Rezoning Transportation Analysis

Petition Number: 2019-174

General Location Identifier: 18313210

Date	Description
01-14-2020	First Review

ILLUSTRATIVE PLAN & NOTES

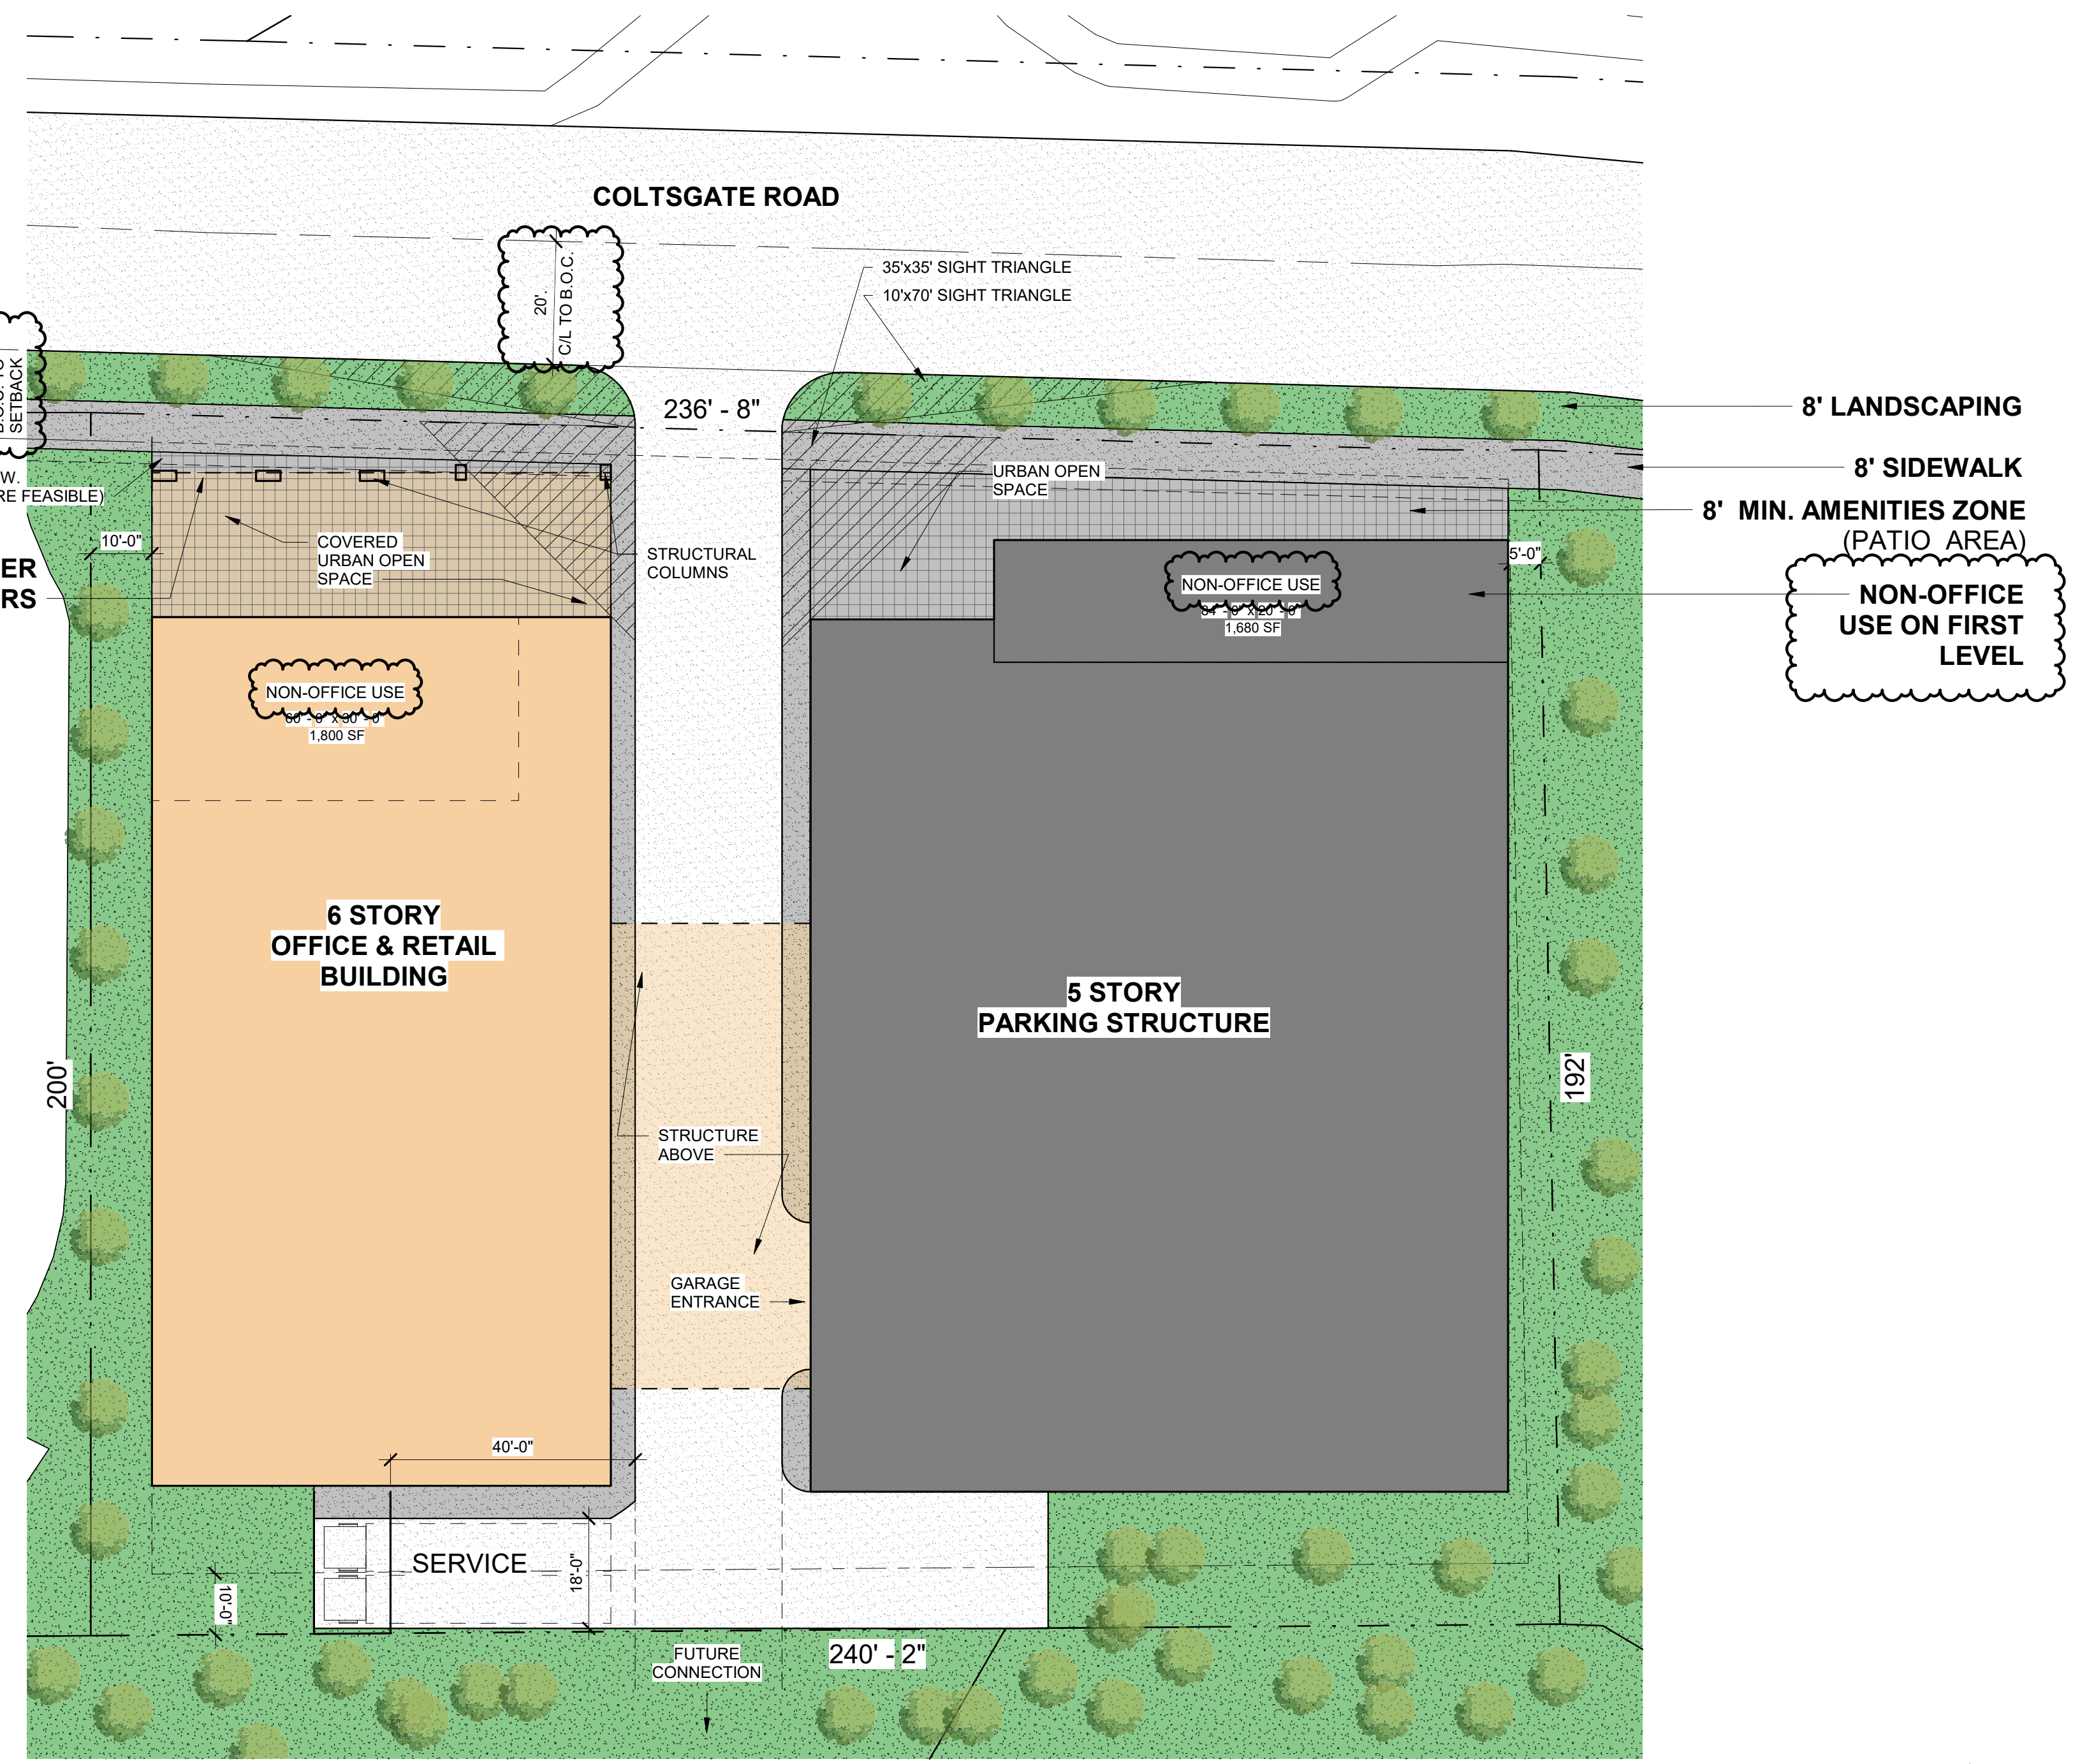
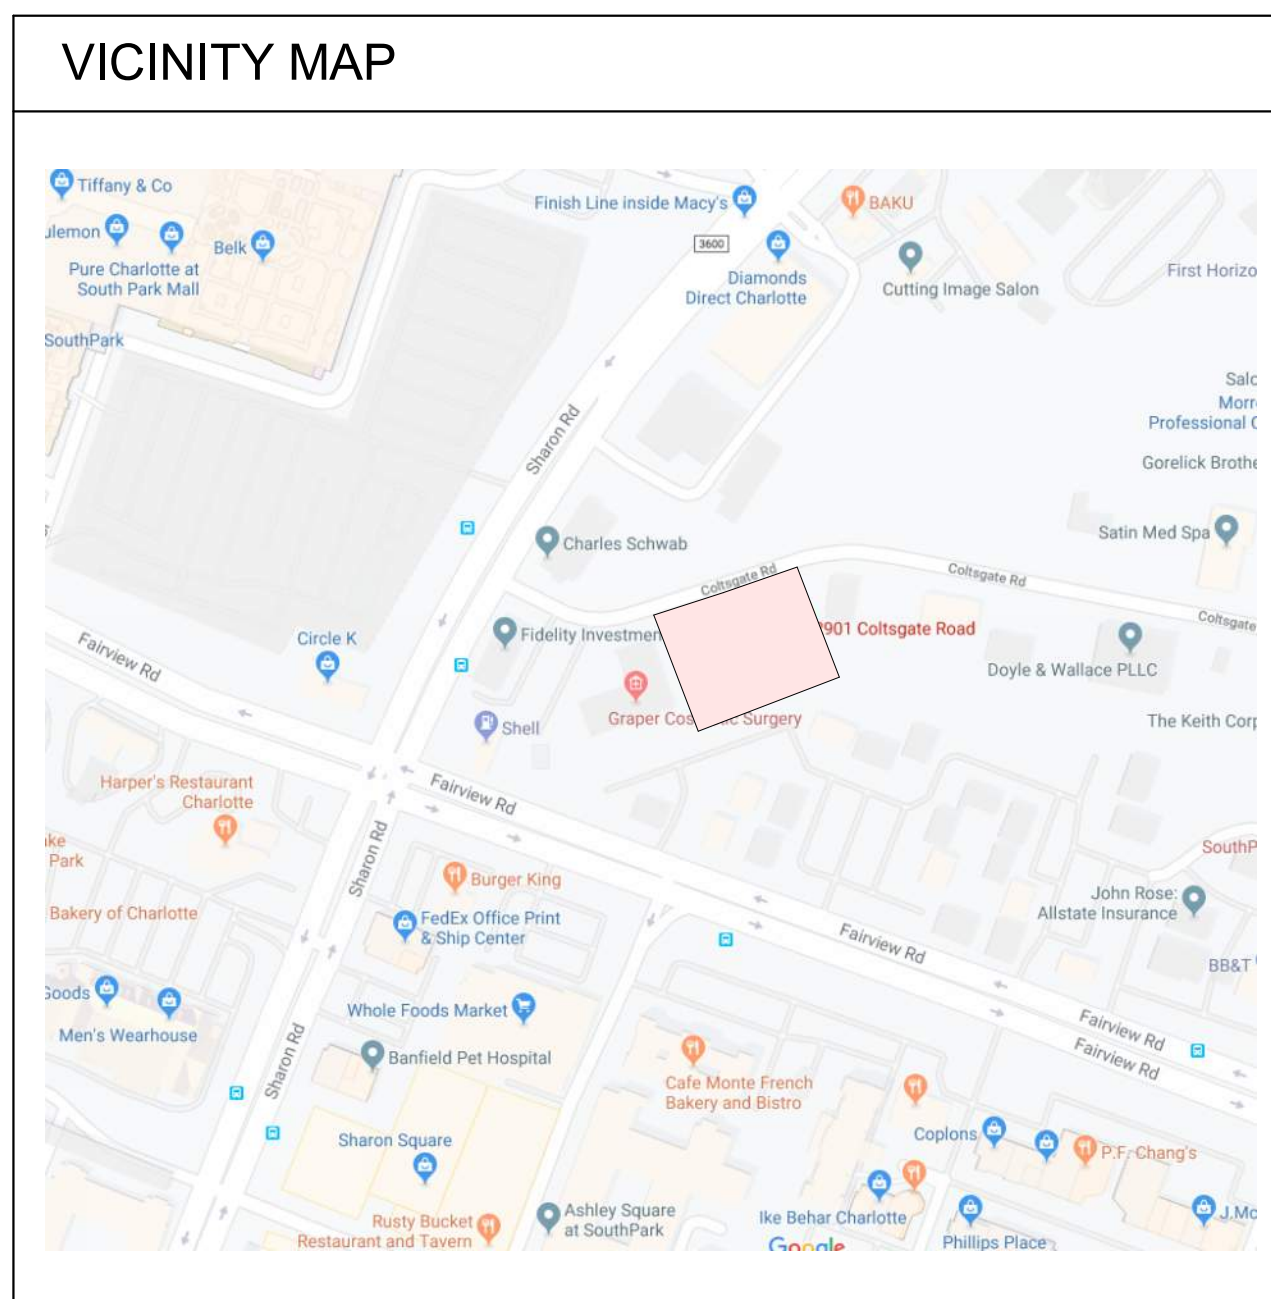
- Curbline** The proposed zoning district has a setback measured from back of the existing or proposed future curbline.
 - Colsgate Road:** The future location of curb and gutter is in its existing location.

The site plan should show the curb and gutter labeled and dimensioned from the centerline for each road.
- Traffic Study** A Traffic Impact Study is necessary for the complete review of this petition because it is near several high contested intersections in the SouthPark area.
- The petitioner should revise the site plan to add a note specifying the extension of the driveway isle to the property line to setup a future grid network for improved future vehicular and pedestrian connectivity in SouthPark due to proximity of several congested intersections in the area.

- The petitioner should revise the site plan to add a note specifying dedication and fee simple conveyance of all rights of way to the City before the site's first building certificate of occupancy is issued. CDOT requests right of way set at 2' behind back of sidewalk where feasible.
- The petitioner should revise the site plan to add a note specifying all transportation improvements will be approved and constructed before the site's first building certificate of occupancy is issued. The petitioner may phase transportation improvements if said improvements and phasing are explicitly described in site plan notes.
- The petitioner should revise the site plan and conditional note(s) to show a dimensioned onsite loading area that can accommodate trash pickup and delivery services.
